P/38/21/PL

Little Sefter Farm Pagham Road Pagham

Extension to existing agricultural barn. This site may affect the setting of a listed building & is in CIL Zone 5 (Zero Rated) as other development.

Proposed Plan and Elevations

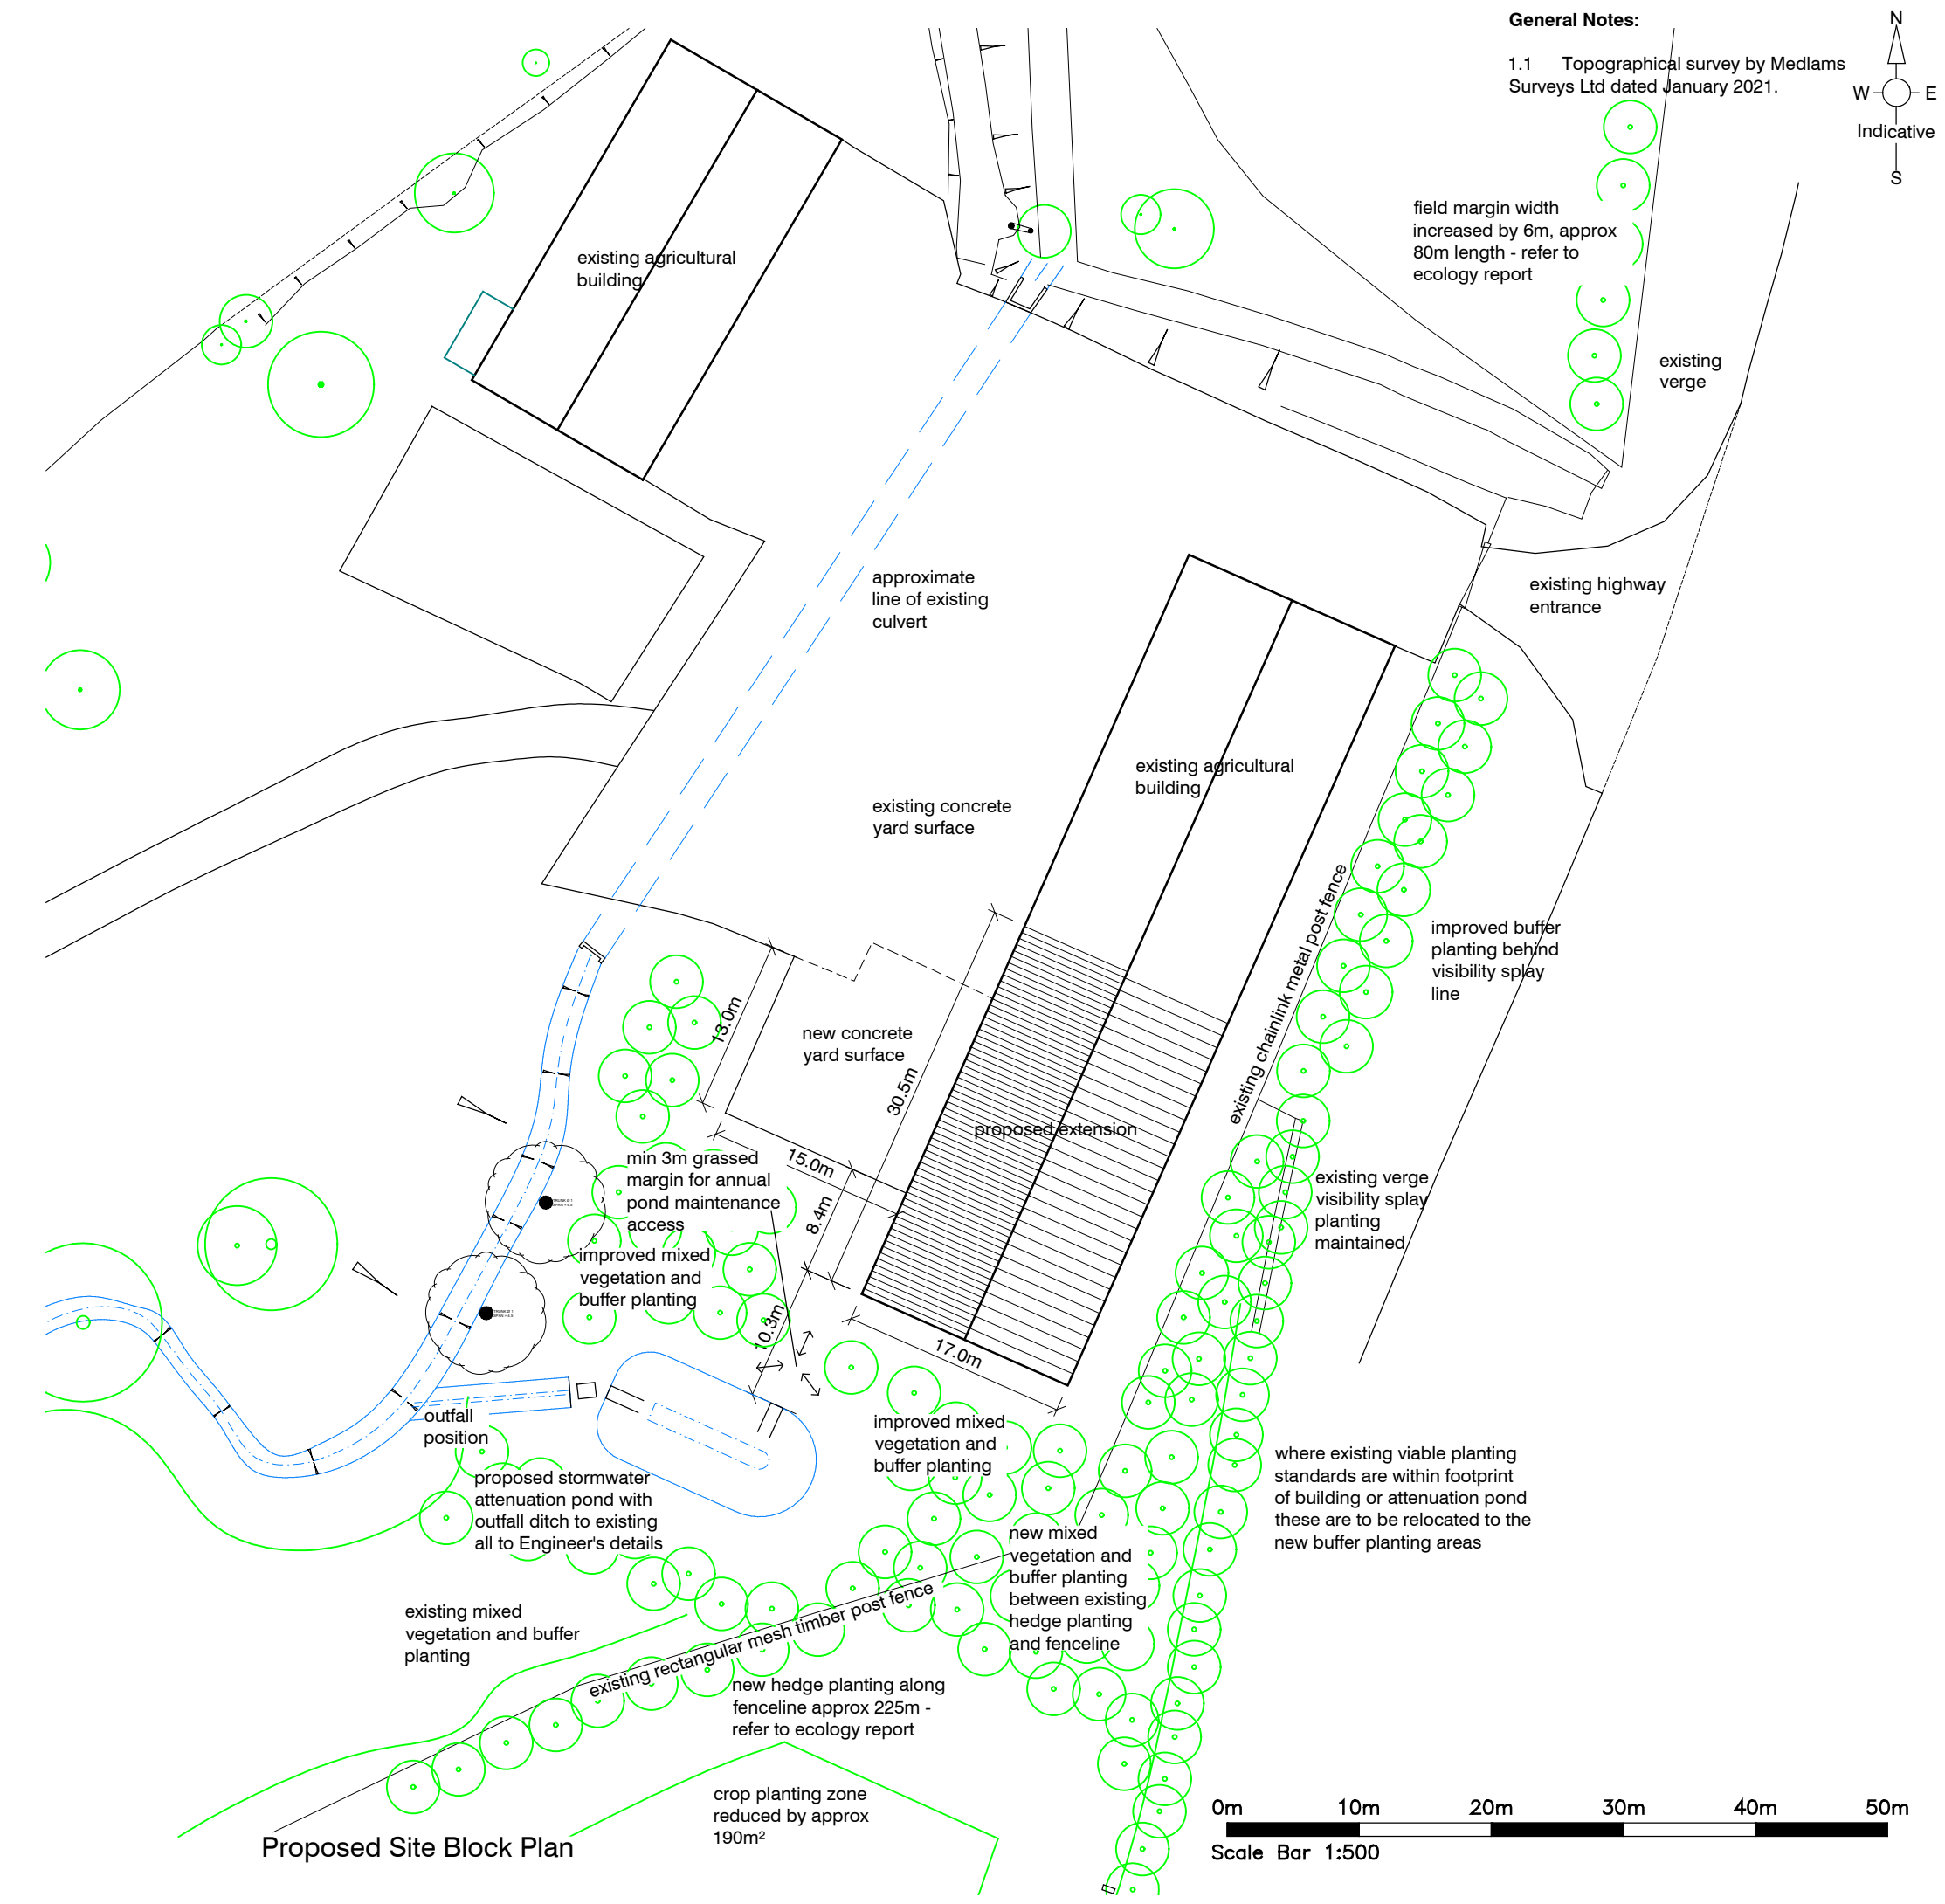
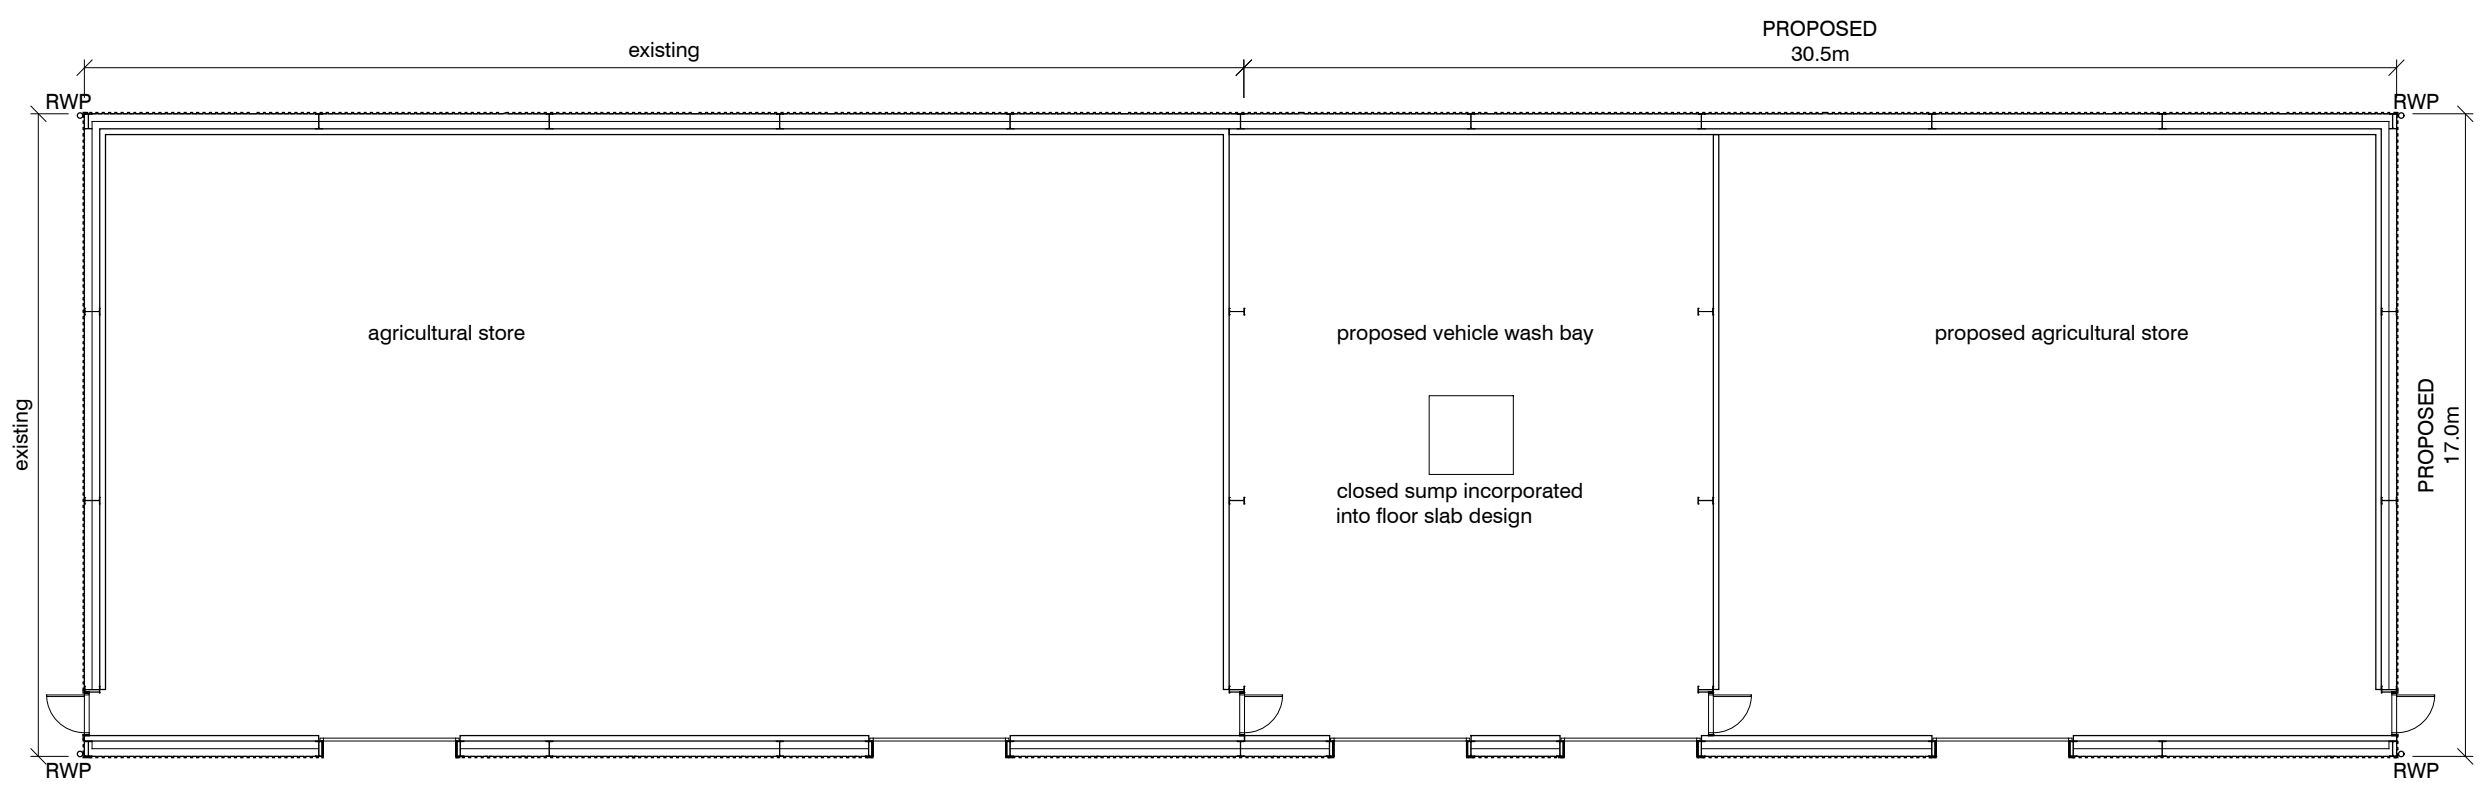
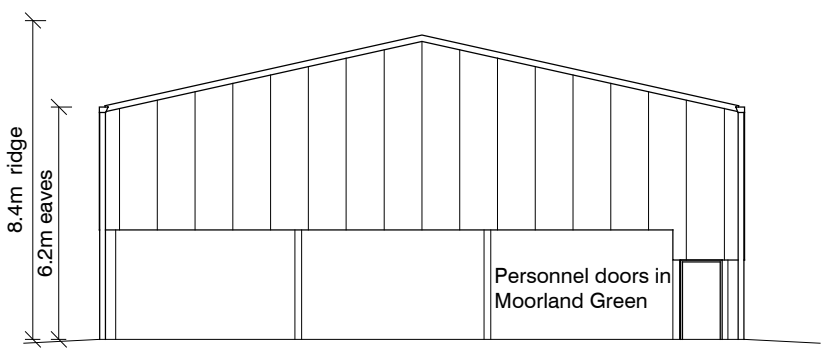
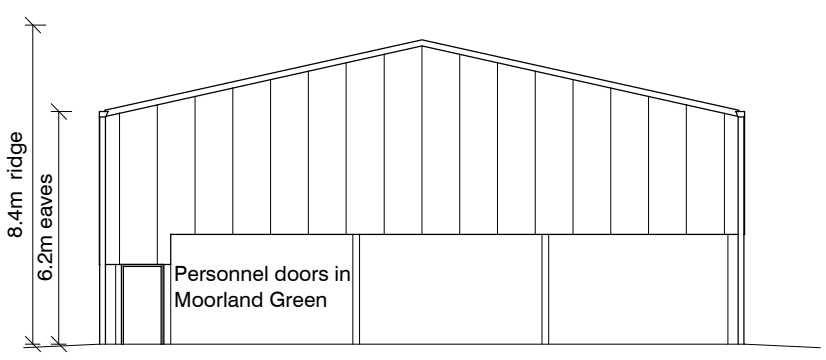
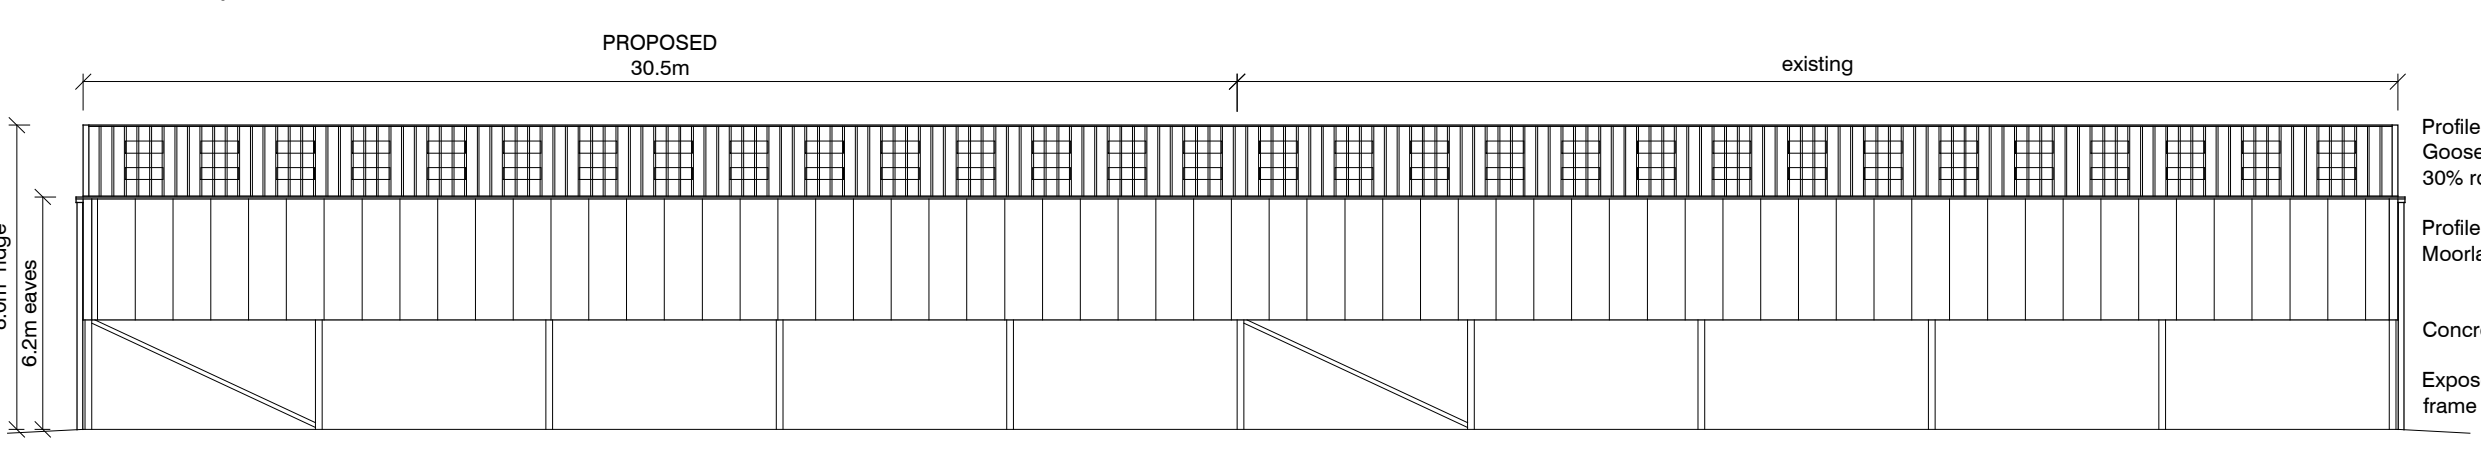
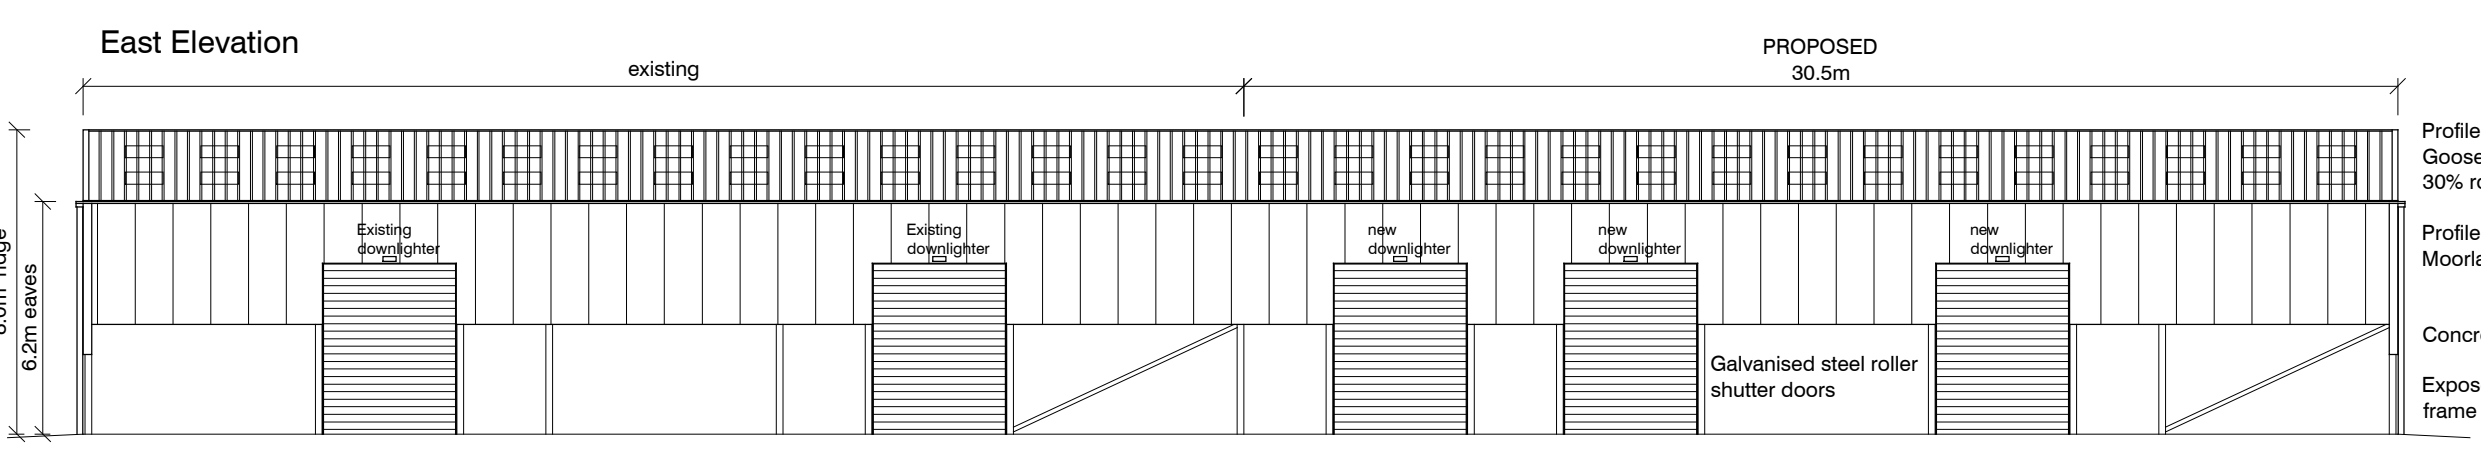
The proposed extension is substantial in size and would appear to of a similar size and appearance to the existing building. There is an existing hedgerow which stretches across the area of the proposed extension, but there is very limited planting in front of the existing building which means it is visible from the road. The existing large building is in view of the listed building when looking in a southerly direction (with The White House on the left hand side), and it is considered that the same will be said of the proposed extension. Both the existing building and the proposed extension do not make a positive contribution to how the listed building is experienced when looking in a southerly direction.

I note that there is an existing line of trees to partially screen the listed building and that the plans indicate that the intention is to increase the buffer planting next to both the existing agricultural building and the proposed extension. This would help to soften the impact of the building and ensure that it is screened from the road. However, it is considered that it would have to be introduced in a more mature condition so as to ensure that it has the desired effect on completion

of the extension (if granted). The reason for this being that the barn is substantial in size (length and height and would still be clearly visible.
